Planning Inspectorate your reference :- EN020002

Dedham Vale East Cable Sealing End Compound

USI1 -* Millwood Road

ALTERNATIVE SITE SUGGESTION FOR THE DEDHAM VALE EAST CABLE SEALING END COMPOUND

Drawing file: EN020002 / EN020002-000521-2.11.5 Design and Layout Plans Dedham Vale East Cable Sealing End Compound.pdf

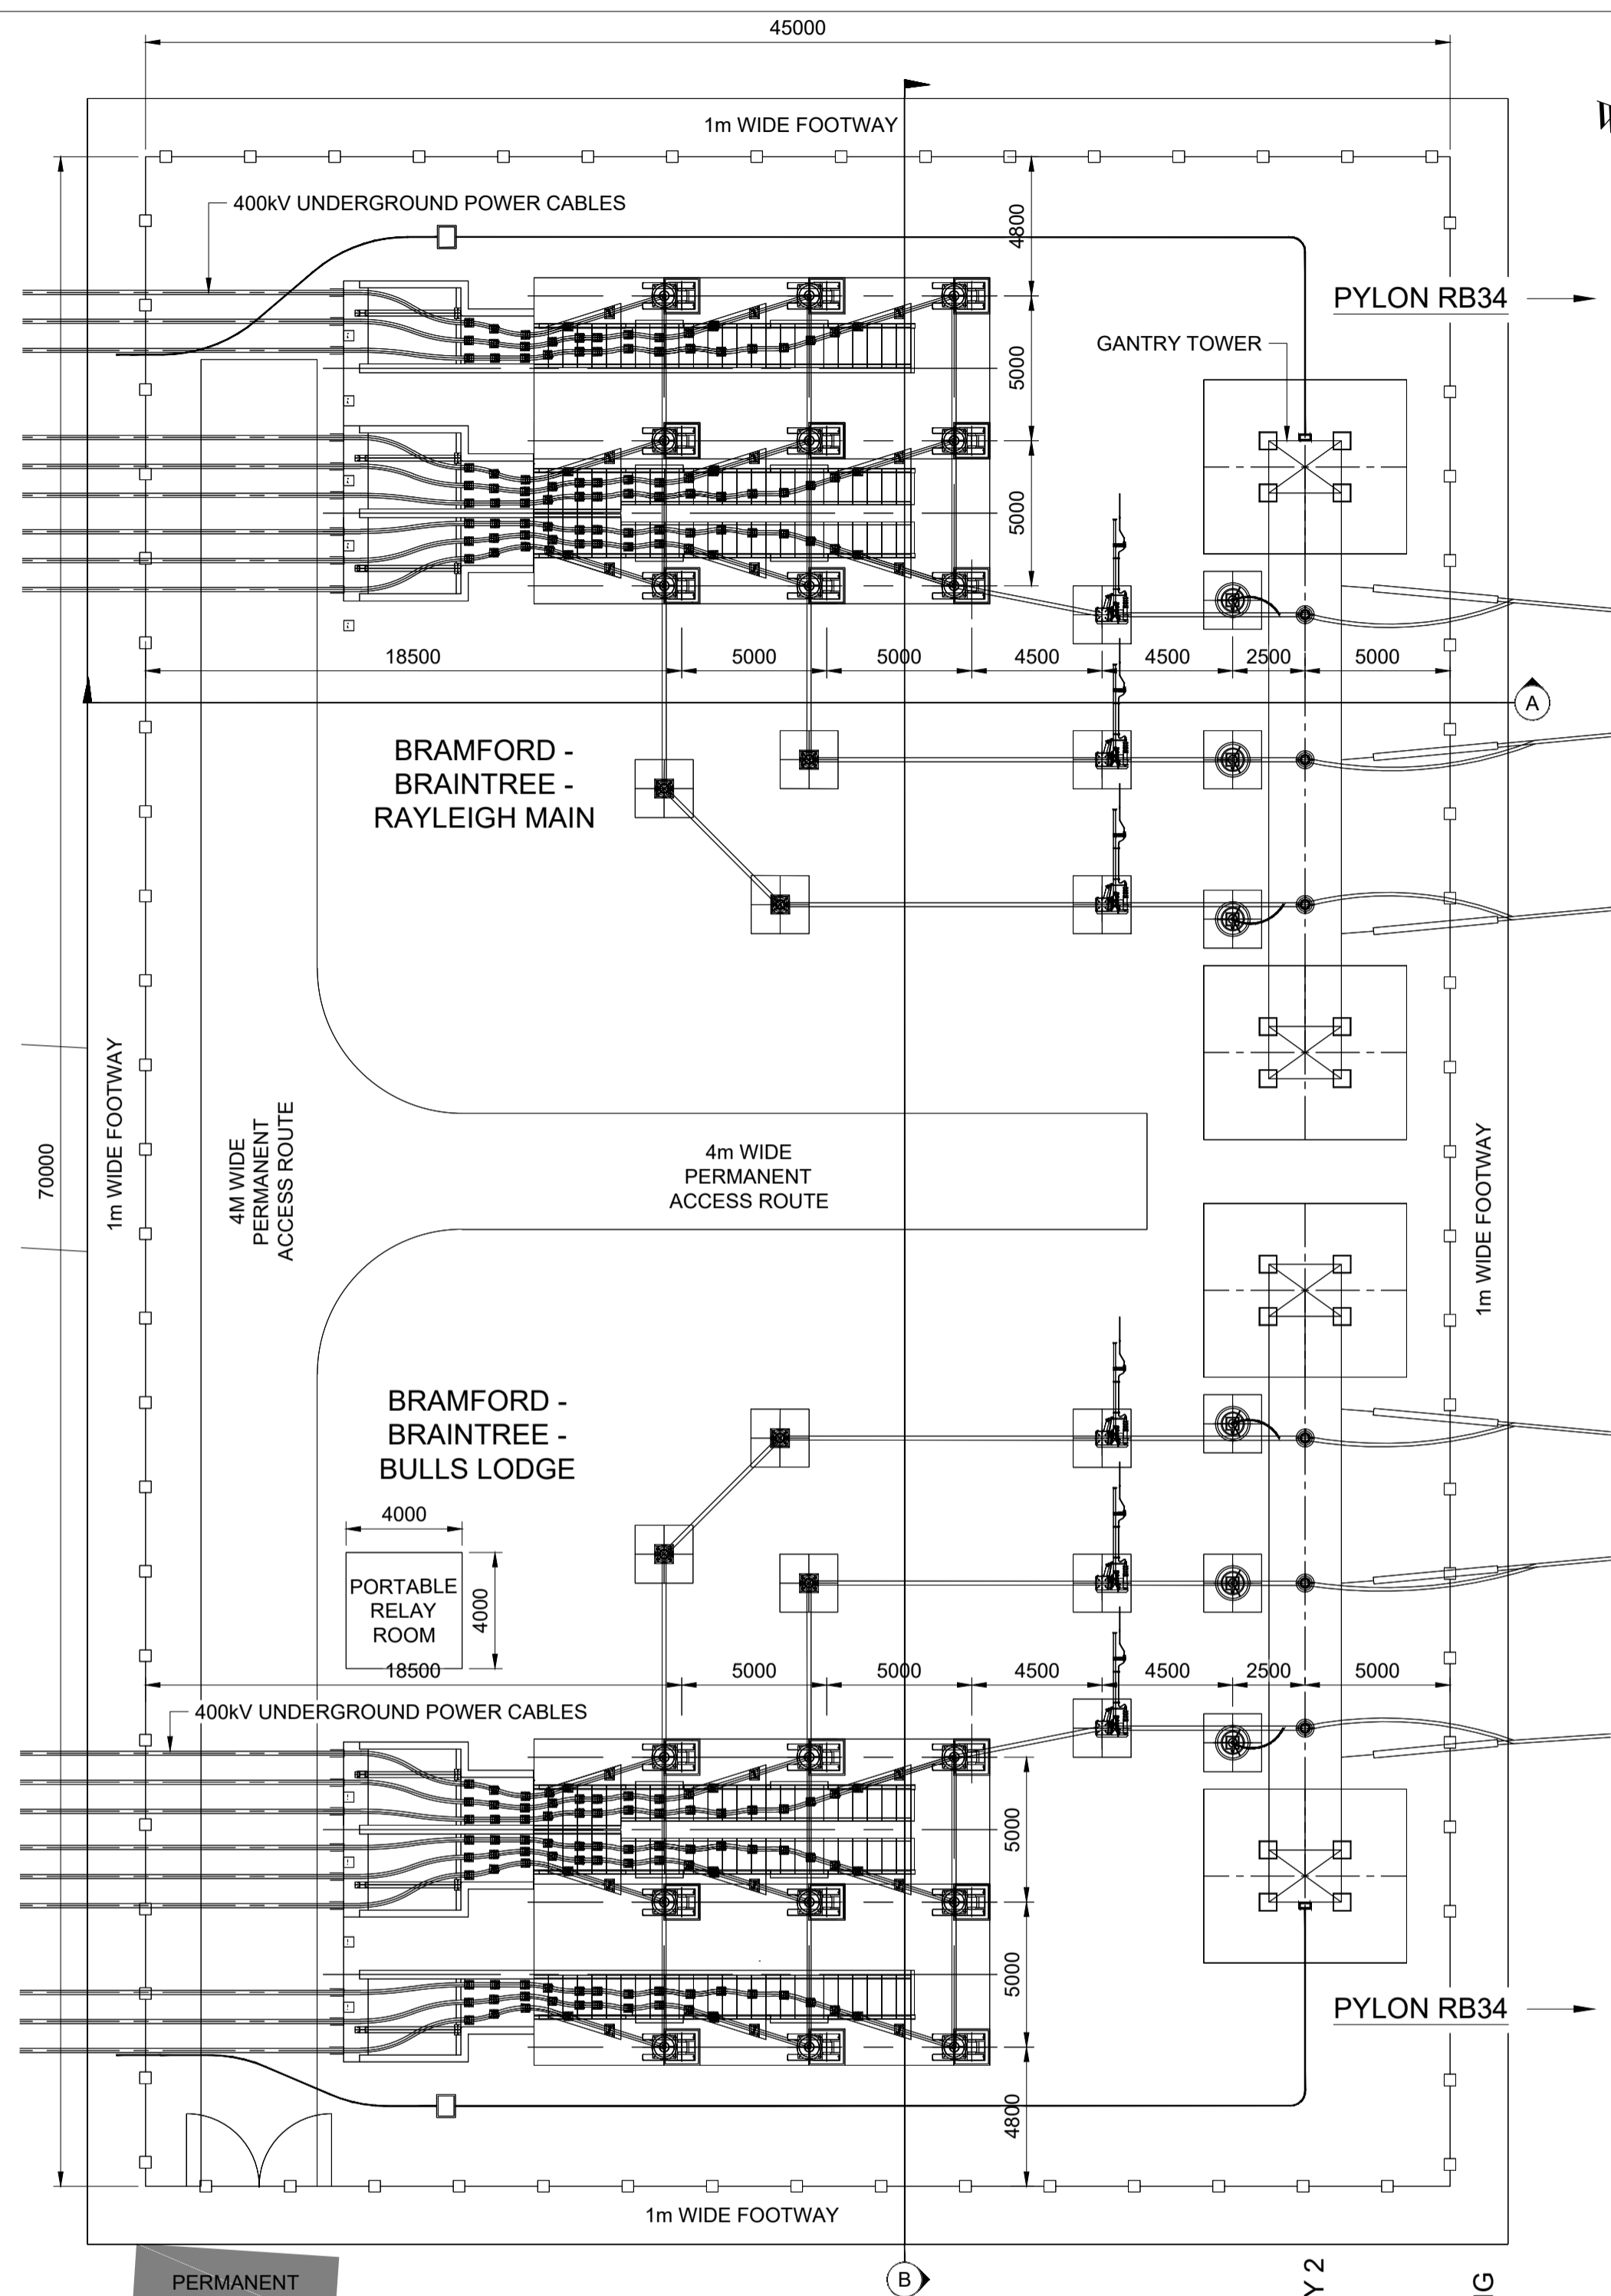
This written representation is to disagree with the location of the proposed **Dedham Vale East Cable Sealing End Compound** on Millwood Road and to propose an alternative site.

The alternative proposed site in the nearby disused gravel pit has significant advantages over the Millwood Road site in every category of the **'Initial Assessment of Principle Issues'**. The land in between the two sites is level and in a straight line so in terms of trench construction, this is a straight forward minor addition in length to the underground trenching with no technically difficult engineering problems.

MILLWOOD ROAD (MR)	DISUSED GRAVEL PIT (DGP)
1. Air Quality and Emissions	
Dust from construction will affect the residential properties at Polstead Heath	No residential properties will be affected in this isolated location.

5. Construction	
Poor road access. Adjacent to residential properties. Use of best and most versatile agricultural land.	Good access from A1071 onto the very wide old gravel pit access road to the site entrance. Isolated, no residential properties in vicinity. Use of derelict land. Plenty of area for any temporary construction compound. No restriction of construction working hours. Isolated location so no health and safety aspects relating to the public.

6. Draft Development Consent Order (dDCO)	
7. Good Design	
Holford Rules	
Rule 3 – <i>“Where possible chose inconspicuous locations for angle towers, terminal towers and sealing end compounds.”</i>	
MR is in direct public view from highways and footpaths.	This site is totally hidden from any public view.
Horlock Rules	
Section II , Number 10 – <i>“.....a range of system and siting options should be evaluated and documented as part of the selection of the preferred solution....”</i>	
If any other options / sites have been considered they have not been noted. This proposal is for a more suitable site, a disused gravel pit, rather than a very visually open site on good agricultural land.

MR access is off a minor lane. The open nature of this site means that perimeter fencing would be obvious and only some additional planting on arable land could be used to mitigate the sealing compound.	There is very good access to the road from the A1071 to the DGP on the old two lane access road directly to the site. The isolated location of the site means that this guideline can easily be adhered to.

13. The Water Environment	
This field is level and is currently free draining. Any construction on this site would require water to be removed, there are no existing ditches in which to guide water away from this field.	This land is all free draining and since the extraction of gravel, slopes to the East allowing the site to be easily drained through the existing large drainage channels which have been dug to keep the site drained.
